Please find below response to the questions raised by the Highways Team.

Subject: Application FG/76/26/PL - Ferring Country Centre

FCC - Overflow Car Park

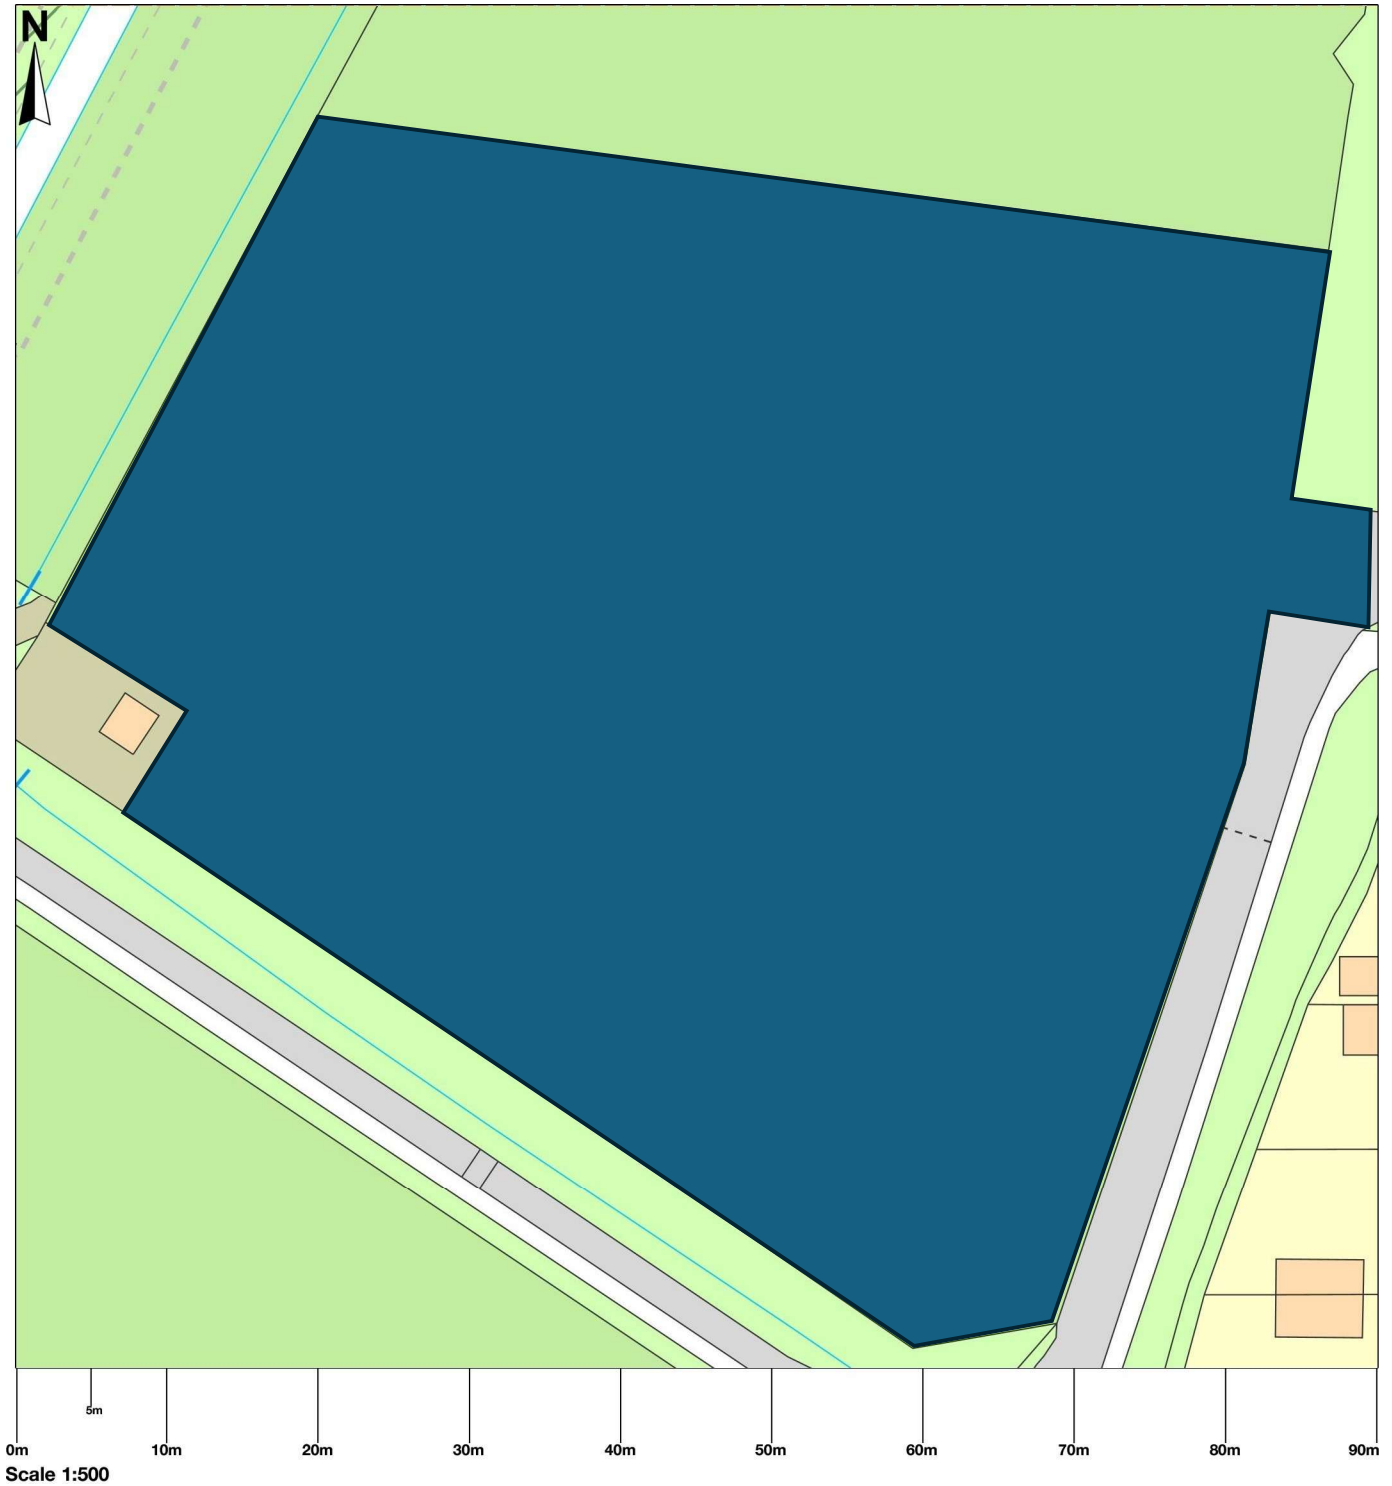
Confirmation of Rife Way access

I can confirm that access to the field is via Rife Way, through the main entrance to our site and across our existing access road.
